Application by Sembcorp Utilities (UK) Limited for an Order Granting Development Consent for the Proposed Tees CCPP Project

The Examining Authority's Written Questions and Requests for Information (ExA WQs)

Issued on Wednesday 18 April 2018

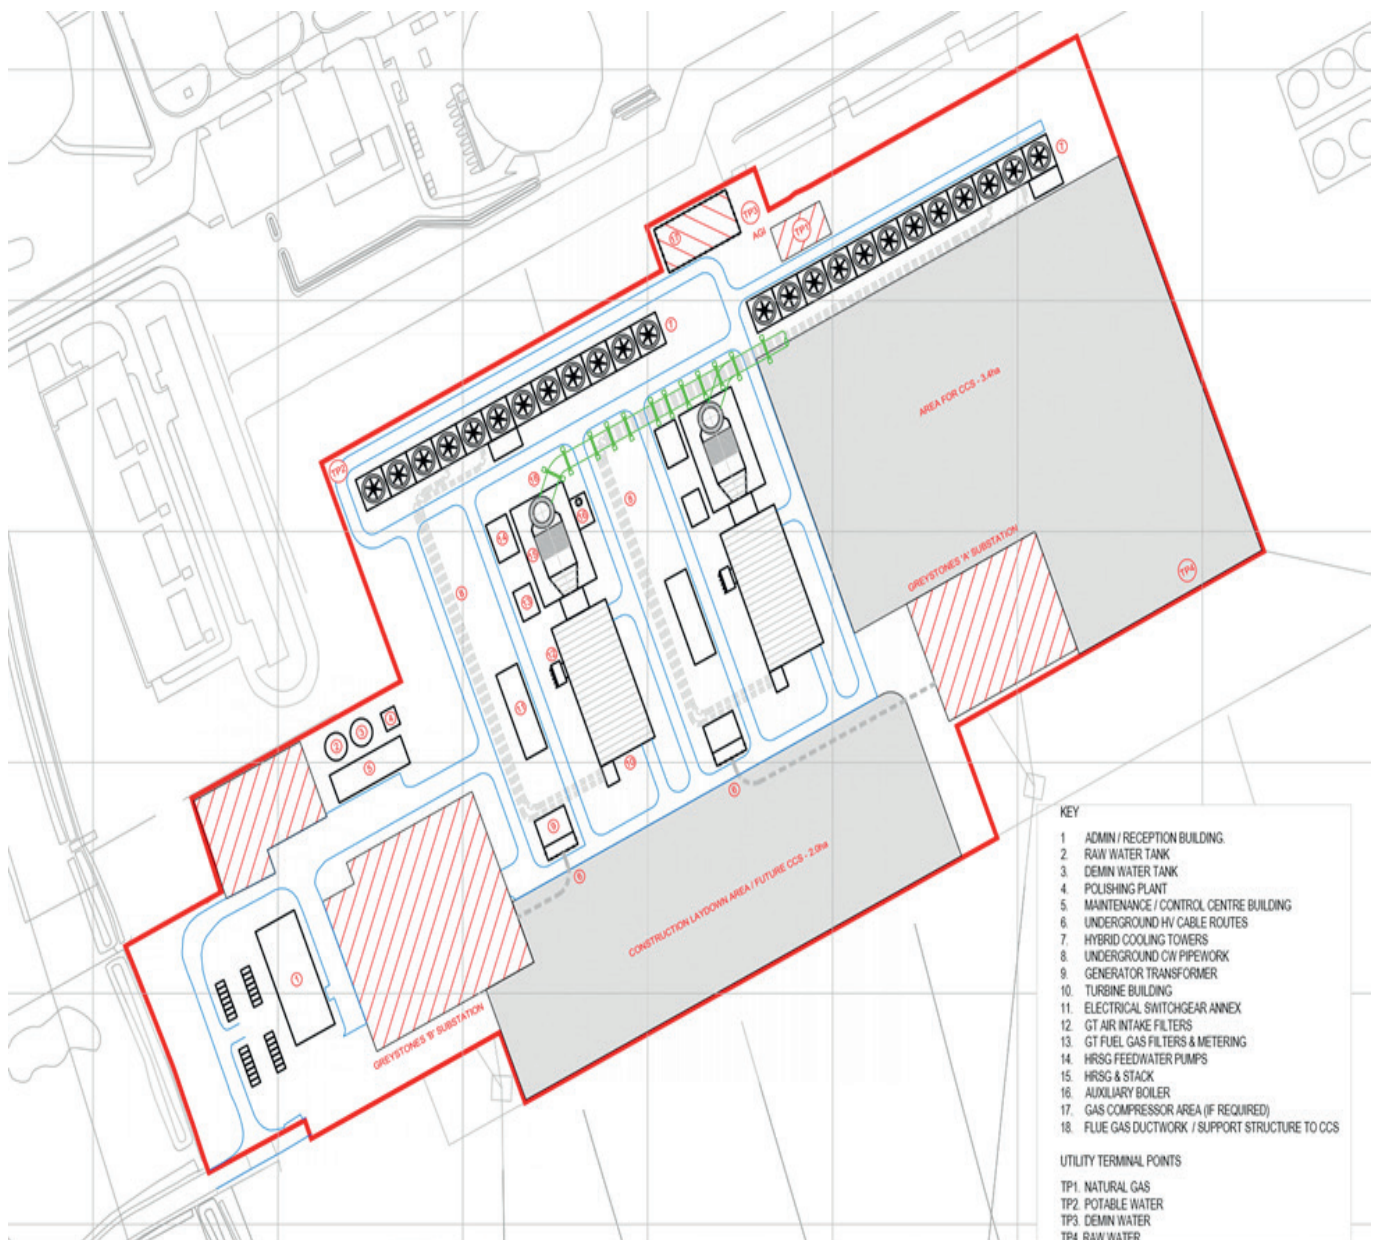
Q2.3.4	<p>Environment Agency Redcar and Cleveland Borough Council</p>	<p>An updated version of the Construction Environmental Management Plan (CEMP) has been submitted at Deadline 4 [version 3, REP4-003].</p> <p>Please confirm whether you are content with the contents of the updated CEMP and provide any comments you may have.</p> <p>The preliminary information provided in version 3 of the CEMP is satisfactory for a project at this stage of its development.</p> <p>In any future iterations of the CEMP, we would advise the following: Section L4.3 of the CEMP could</p>

Ref No.	Respondent:	Question:
		<p>be amended to encourage the Applicant to maximise the re-use of suitable waste materials within the site boundary, within the terms of a relevant exemptions. Thereby, reducing landfill costs and minimising the use of virgin natural resources.</p> <p>Table L4.5 of the CEMP refers to Pollution Prevention Guidance Notes but it should be noted that these are under review and may not be up-to-date guidance. We, therefore, recommend the Applicant also reviews Pollution Prevention for Businesses webpage on GOV.UK for current pollution prevention advice to be incorporated into future versions of the CEMP. The webpage can be found at the following: https://www.gov.uk/guidance/pollution-prevention-for-businesses</p>
Q2.5.1	Environment Agency	<p>Does the EA consider that the Applicant has addressed the points raised in the EA’s WR regarding the Water Framework Directive (with the exception of opportunities for enhancement measures, which the ExA understands is to be covered in the forthcoming revision to the SOCG)?</p> <p>We can confirm that the Applicant has addressed the points raised in our previous written representations response regarding the Water Framework Directive. I attach a copy of an email to the Applicant dated 14 June 2018 as Appendix 1 and a subsequent letter sent to the Applicant on 11 July 2018 as Appendix 2 which forms part of our submission on the second round of written questions. The email and letter sets out our position with regard to WFD issues.</p> <p>In summary, we have assessed the submitted WFD information and consider that the proposed development will have no significant adverse impact upon WFD waterbodies. We acknowledge that it seems highly unlikely that it will be possible to implement mitigation measures to remediate the watercourses within the proposed site. It is also considered that the existing modifications at the proposed site are not significant in the context of the waterbody. We have also advised that there are other practicable opportunities to improve the waterbody as part of the proposed development with regard to environmental enhancement opportunities.</p>
